*Berry, Huff, McDonald, Milligan Inc.*  
*Engineers, Surveyors*

May 23, 2013

RE: Level I-Minor Residential Development Review Site Plan Revisions  
Level II-Preliminary & Final Site Plan Development Revisions  
Chabad Lubavitch of Maine LLC.  
Pomeroy Street

**Comments from Nell Donaldson, City Planner, dated May 15, 2013 for street extension:**

SHEET
1
REPRODUCTION OR REUSE OF THIS DOCUMENT WITHOUT THE EXPRESSED WRITTEN CONSENT OF BH2M INC. IS PROHIBITED

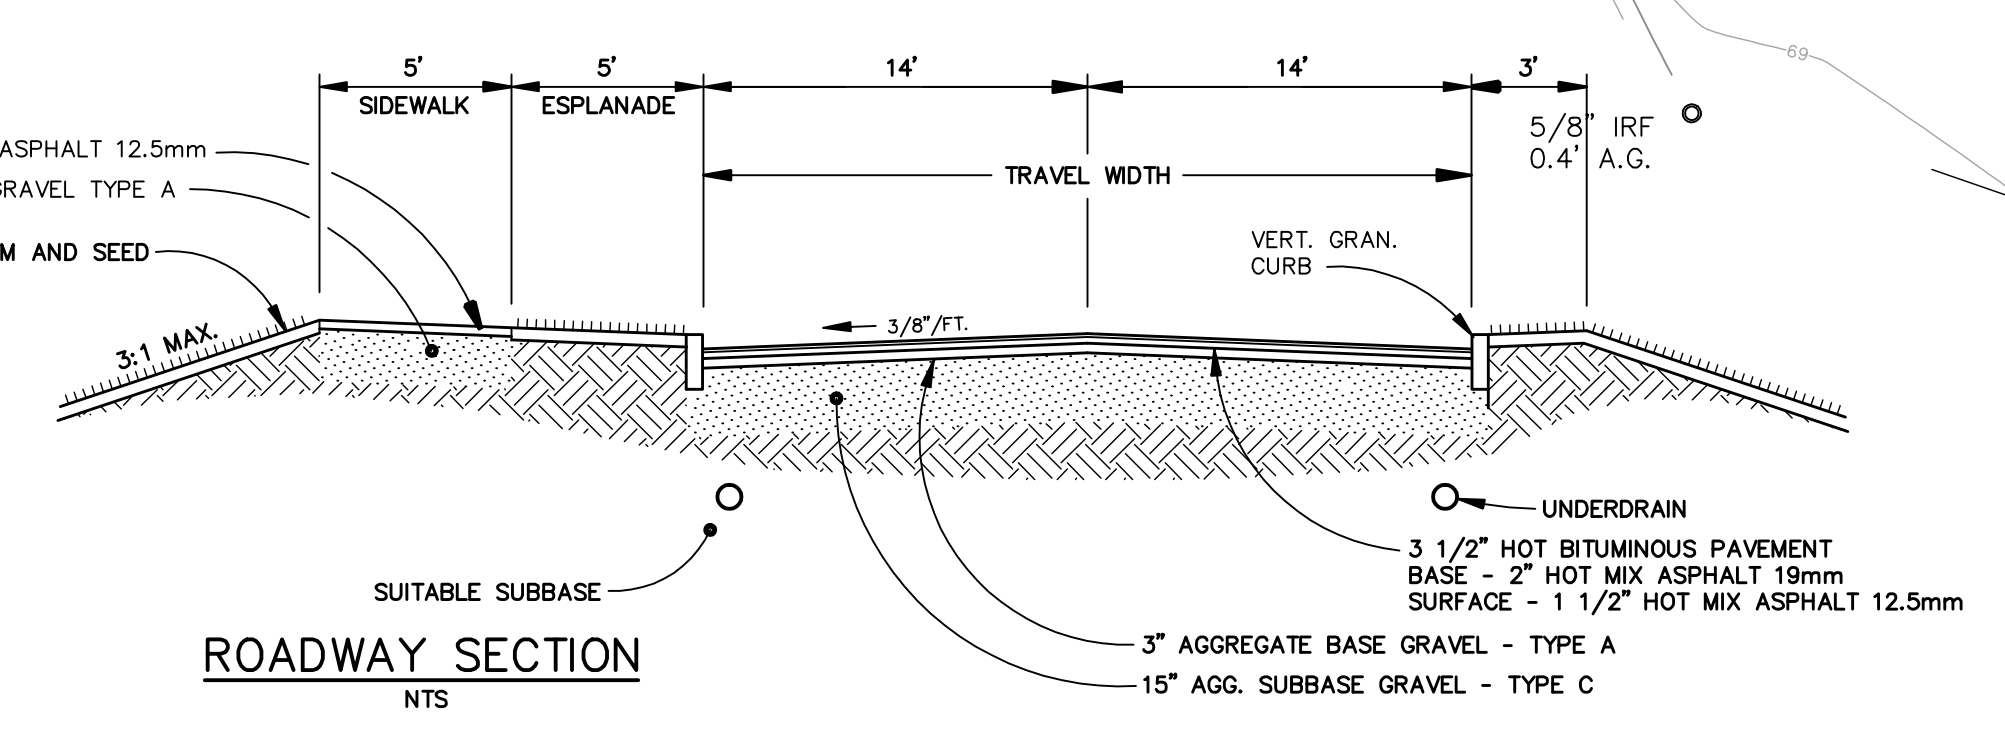
1. The plans have been revised (see sheet 1 of plans) to include a turnaround with a depth of 30 feet as required by the City Technical Manual, Section I-3 and Schematic I-5.

1. The plans were revised to assure there were no conflicts on the western side of Pomeroy Street as requested between utilities and proposed landscaping (see sheet 1 of plans).
2. Please find attached a copy of the revised wetland alteration permit submitted to the Maine DEP for this project. A copy of the permit will be forwarded to your office once it has been approved by the Maine DEP.
3. Please find the following revised calculation regarding the urban impaired stream standards that exclude the impervious and landscaped areas associated with the single family residential house:

8. A 1-foot wide grassed shoulder has been added along the Eastern side of the proposed Pomeroy Street (see sheet 1 of plans).
9. A temporary erosion control mat has been added along the inslope of the Eastern side of Pomeroy Street above the curtain drain per Maine DOT Specifications (see sheet 1 of plans).
10. Curtain drain clean outs have been added to the storm drain system as requested (see sheet 1 of plans). A detail of this cleanout was also added to sheet 5 of the plans.
11. The pipe crossing Pomeroy Street from the end of the curtain drain to the existing catch basin in Bancroft Street has been specified on the plans to be a 10-inch diameter stormdrain (see sheet 1 of plans).

1. The driveway to the proposed residence has been reduced in size to 10-feet in width as requested (see sheet 1 of plans).

2. The driveway has also been relocated slightly to the southeast away from the abutting residence of Briggs as requested (see sheet 1 of plans). The plans have also been revised to add a ditch along the northerly portions of the site improvements as well as along the Western side of the Pomeroy Street improvements to assure that no runoff from the site is directed to the abutting property owned by Briggs.

1. The site plan has been revised to include the existing and proposed treelines.
2. The footprint of the proposed building totals 2,688 s.f. in size. Please contact Gleason Architects to determine the total building square footage.

SHEET
5

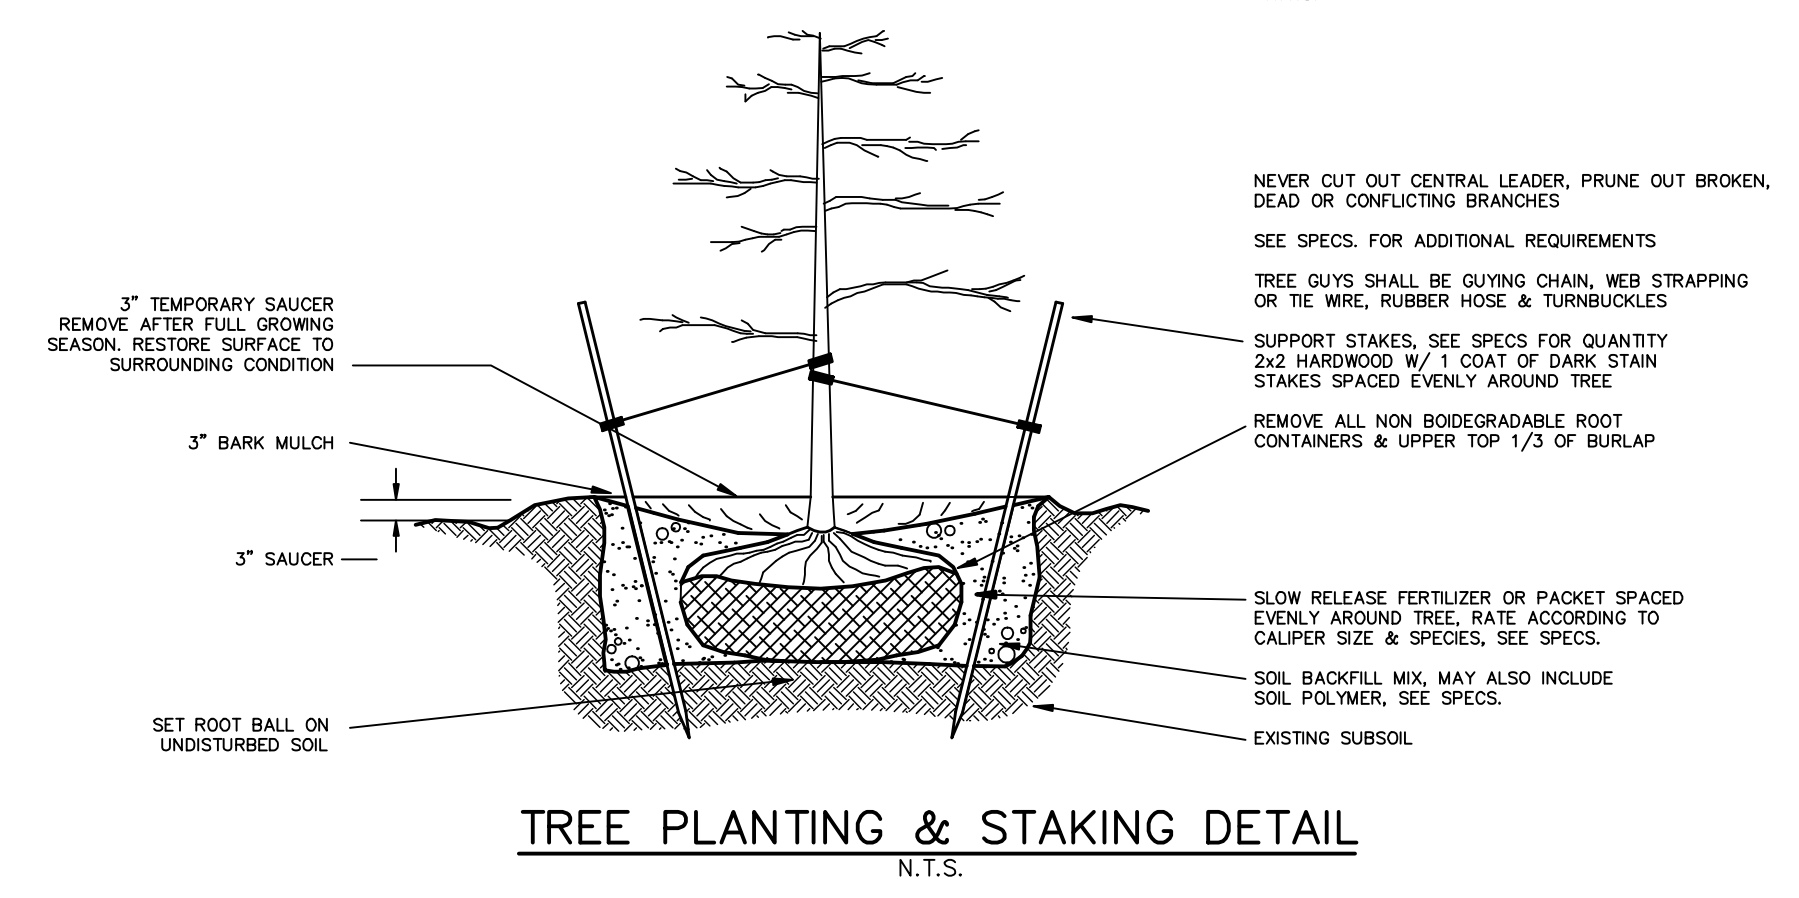
4. Please find attached a revised stormwater management report for your review based on the City Comments.
5. The curtain drain detail included on sheet 5 has been revised as requested to include a sand filter layer.
6. The Operations and Maintenance plan included in Appendix D of the revised stormwater management report (attached) has been updated as requested to include information on the proposed curtain drains.
7. As noted in the review letter from the City, David Margolis-Pineo of the City's Department of Public Services has agreed that the City will be

1. A street light detail has been added to sheet 5 of the plans as requested.
